Our ref: DOC19/981988  
Senders ref: SSD-10364

**Subject:** EES comments on Environmental Impact Statement for Visy Dry Recyclables – SSD-10364 – 112-120 Euston Road, Alexandria

- Environmental Impact Statement (EIS) – November 2019
- Appendix C – plans, including Landscape Plan (drawing No DA09.01 C)
- Appendix K – Soil water and flooding assessment – 31 October 2019
- Appendix S – BDAR Waiver documents
- Appendix T – Arboricultural Assessment (AA)– 29 October 2019

Figure 2.1. Encroachment into tree protection zones from EIS Aboricultural Assessment

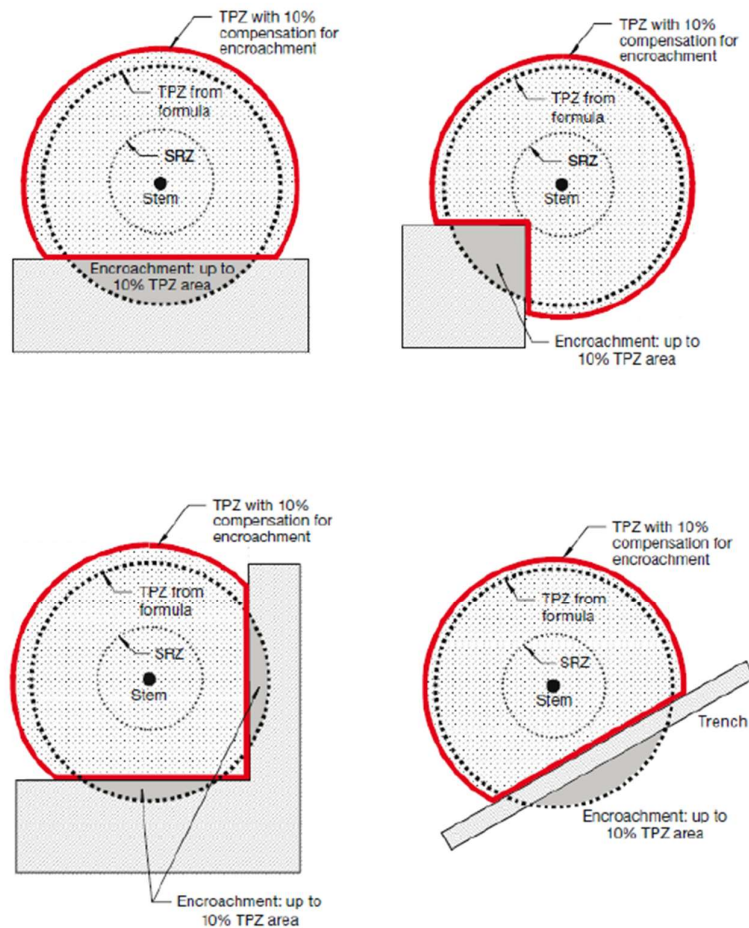
The AA indicates the development will retain three *Celtis sinensis* (see Appendix B, page 14). Prior to approving the AA and Landscape Plan for the site, it is suggested the Department considers information that is available relating to this invasive, exotic tree, for example the NSW Department of Primary Industries website (DPI NSW Weedwise) indicates:

The spread of seed from this invasive tree from the site is of concern, particularly as the DPI Weedwise link indicates that current infestations are largely in riparian zones and an open concrete lined stormwater channel runs along the northern boundary (BDAR waiver, page 10) in close proximity to these trees and the channel flows into Alexandria Canal, the Cooks River and Botany Bay. It is recommended:

- *Celtis sinensis* is removed from the site and replaced by local native provenance species and a condition of consent is included to this effect. Any resident fauna potentially impacted by the removal of these trees should be relocated in a sensitive manner under the supervision of a qualified ecologist/licensed wildlife handler.
